From: [Maguire, Ian](#)
To: [Aquind Interconnector](#)
Subject: Portsmouth City Council response to the request for information from the Secretary of State of 23rd May 2023
Date: 20 June 2023 21:24:39
Attachments: [PCC Comments re SoS Request for Furhter Info - JUNE 2023.pdf](#)

RE: Application by AQUIND Limited for an Order granting Development Consent for the AQUIND Interconnector Project - Response of Portsmouth City Council and Coastal Partners as Interested Parties to the Secretary of State's Request dated 23 May 2023 for Comments upon the Applicant's Response of 28 April 2023.

1 Optical Regeneration Station(s) Compound Plan View
1 : 75

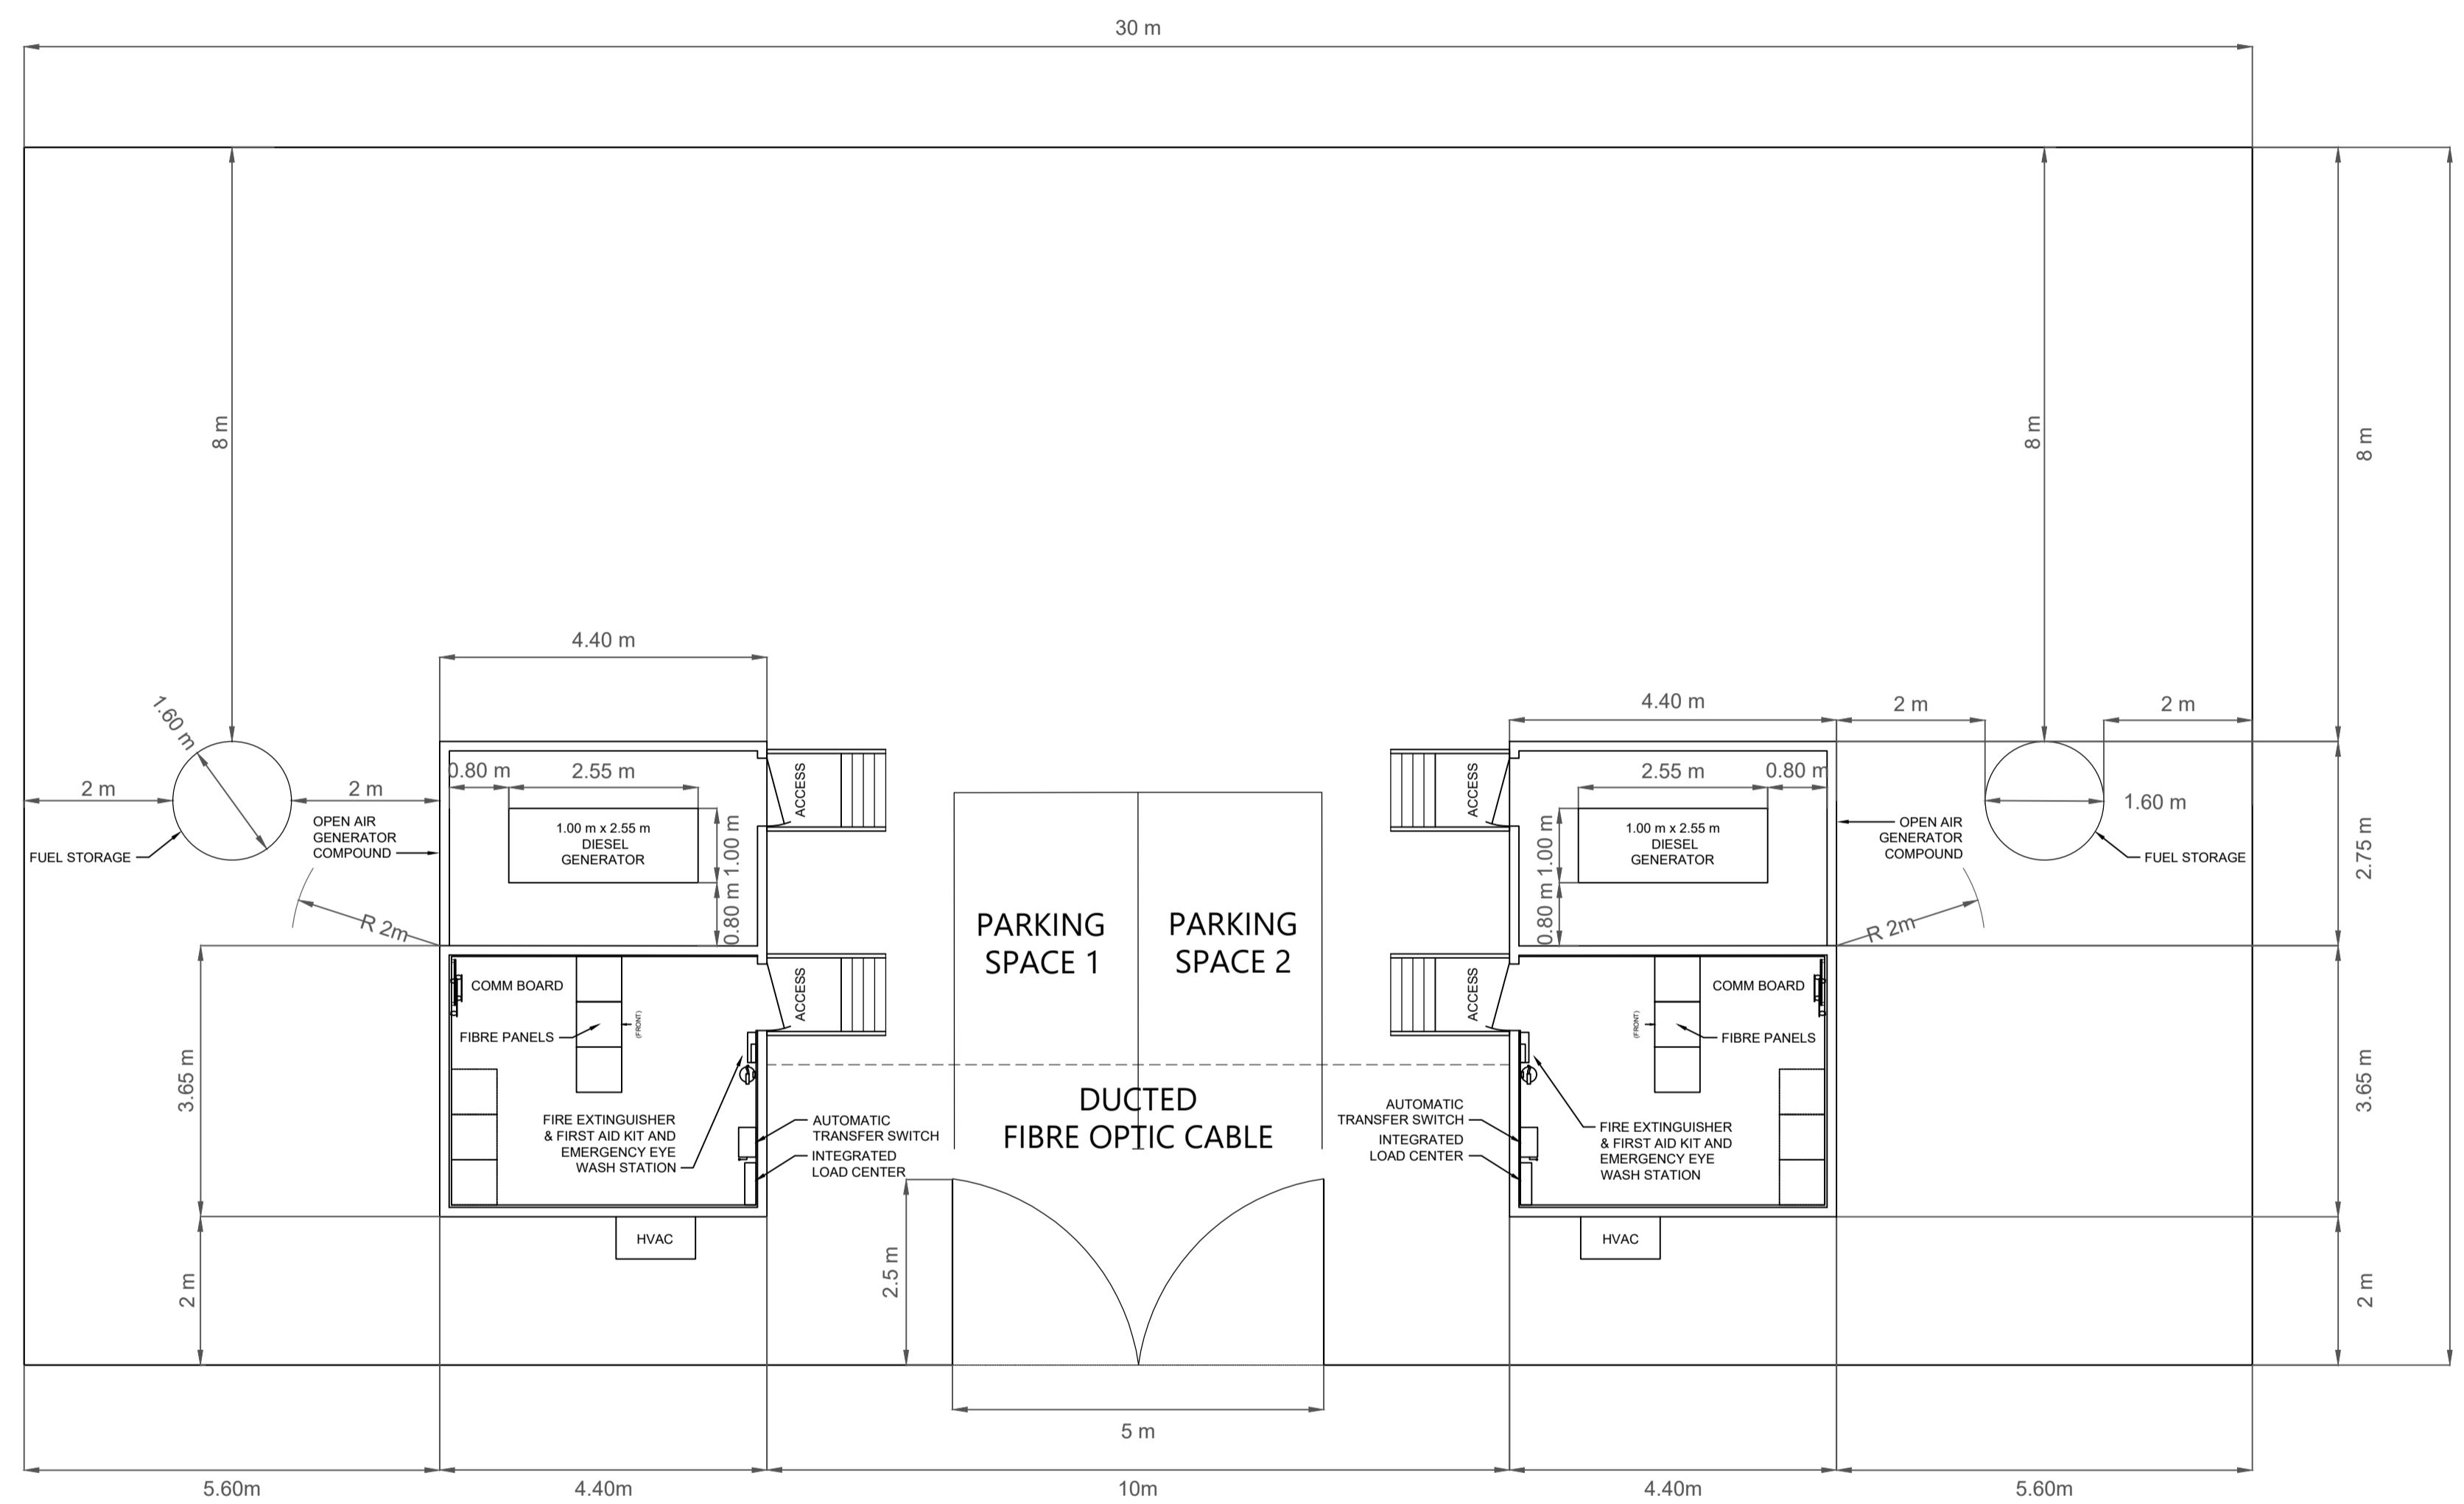
- 5.5 The Applicant of course maintained through the examination, and during the Secretary of State's post examination consultations, that the optical regeneration station ('ORS') compound required the inclusion of an 8m wide stand-off space inside the compound fencing to allow for the protection of the ORS from established trees to the North which could fall. This was whether or not the FOC elements were included.

- 5.6 Thus, as argued by the Applicant, the compound as proposed by the Applicant needed to have dimensions comprising 35m long x 18m wide in order to include the 8m stand-off. Those dimensions generated an area of 630m².

- 5.7 The Council would first note that the Applicant now identifies an area of 559m² area within the Book of Reference (as updated) and the 630m² previously identified and maintained (even in the absence of the commercial FOC as an element) has been reduced. Whilst it is welcome that less of the Council's land is said to be required, no explanation has been given for this.

- 5.8 Furthermore the matter of the stand-off within the suggested area was challenged by PCC previously (see its response of 30 September 2021) and these points were never satisfactorily concluded. PCC would therefore repeat its concerns that, even though the Applicant has reduced the area required it has not explained or identified

how this is the minimum area necessary for the scheme in order to help satisfy the justification for the compulsory acquisition ('CA') of this land.

- 5.9 The latest Book of Reference in respect of the ORS itself 'without commercial FOC' identifies a CA area of 492 m²; this accords with an ORS compound with dimensions 30m x 16.4m (including 8m stand-off at rear). However, the Council contends that a smaller compound (and CA area) of, for example 30m x 9.4m = 282m² (allowing for 1m rear stand-off to fence) would be more appropriate with a separate restriction on the land agreed (although of course without prejudice to PCC's general position) to prevent trees being planted in the 7m gap north of the ORS compound.
